From: Sue Howell <Sue.Howell@arun.gov.uk>
Sent: 31 March 2022 16:07
To: Planning.Responses <Planning.Responses@arun.gov.uk>
Cc: Simon Davis <Simon.Davis@arun.gov.uk>
Subject: Planning Consultation on: Y/3/22/OUT

Response to Planning Application

Application ref: Y/3/22/OUT

Location: Land West of Bilsham Road Yapton

Illustrative Landscape Masterplan 964-MP-02B
(Indigo Landscape Architects)

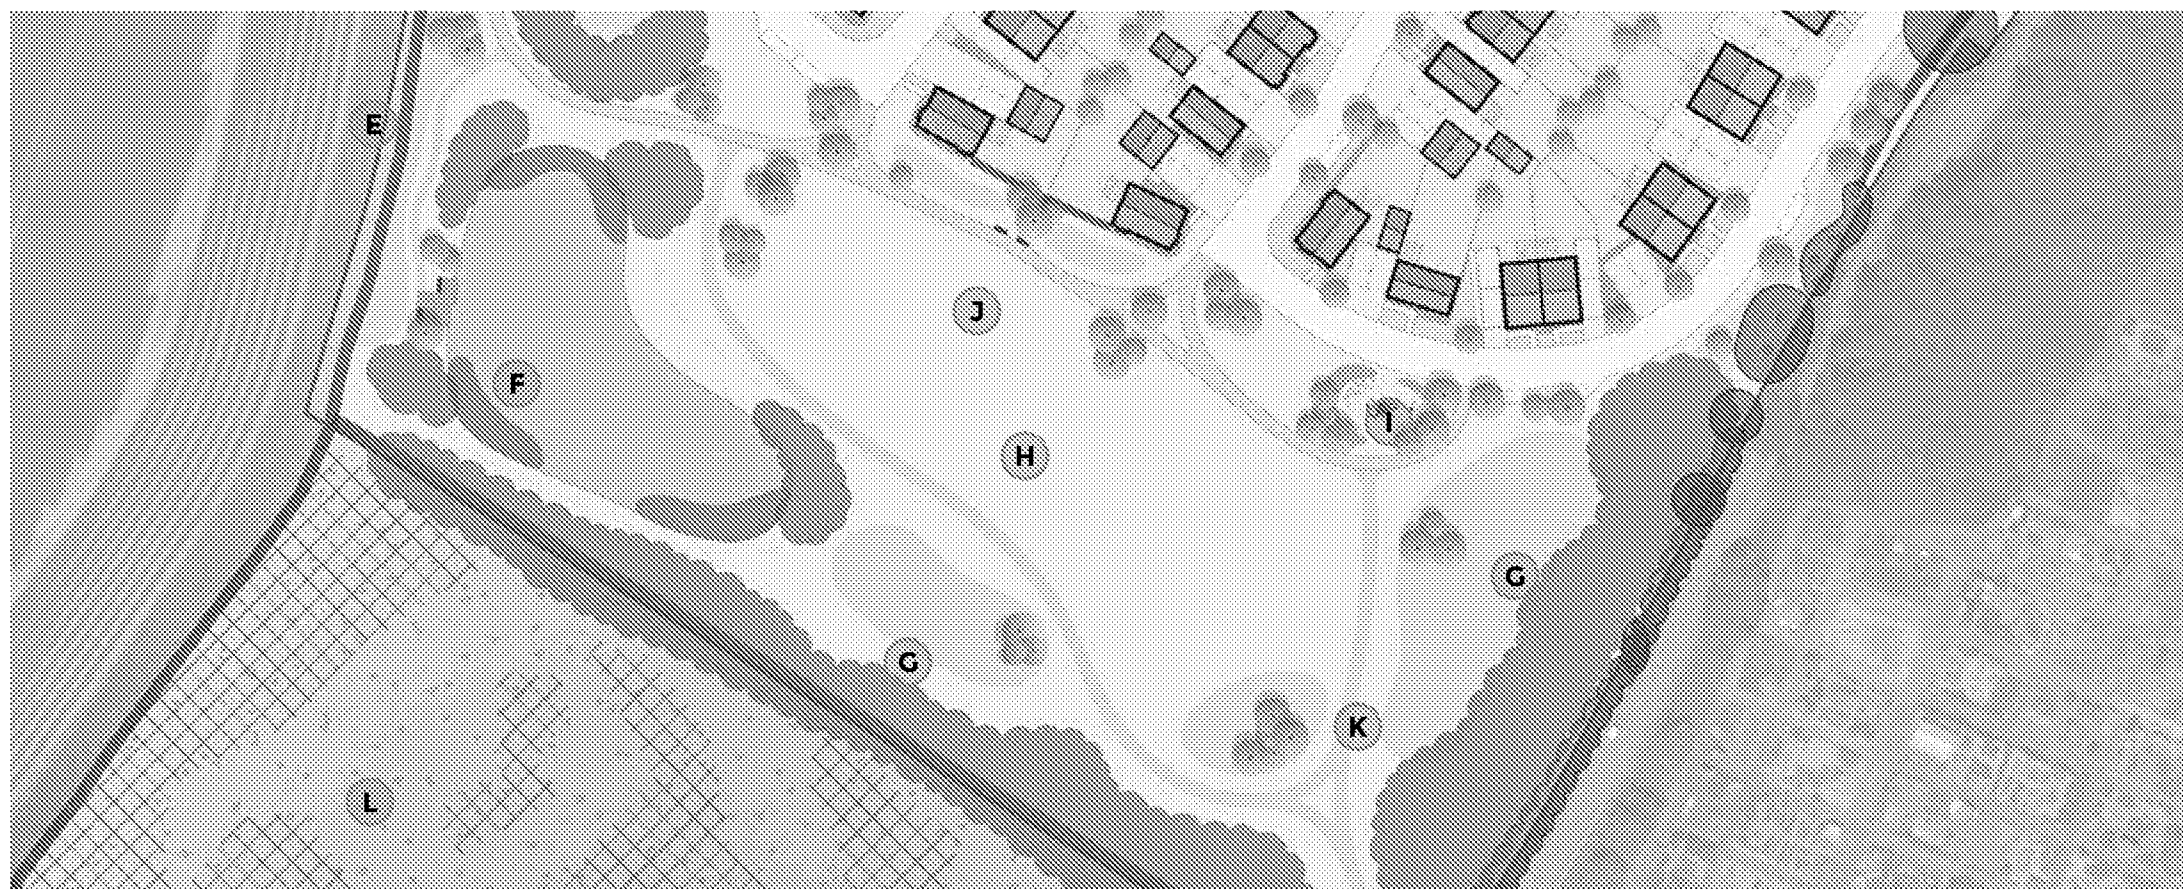
The illustrative landscape masterplan appears to be well thought out including good areas of usable POS across and within the site. There has been detail of play included within the detailed phase and indication of potential connectivity to the SD7 development to the north which is good to see.

The open indicated area of POS would appear to allow buffer zone areas which would promote wildlife corridors and village green area to break up the built form and provide sense of place. SuDS features have been indicated to the south of the site where it would need to be demonstrated that these do not compromise the POS available and existing vegetated tree buffers whilst providing green infrastructure for the proposed development should not be relied upon as serving the POS requirement.
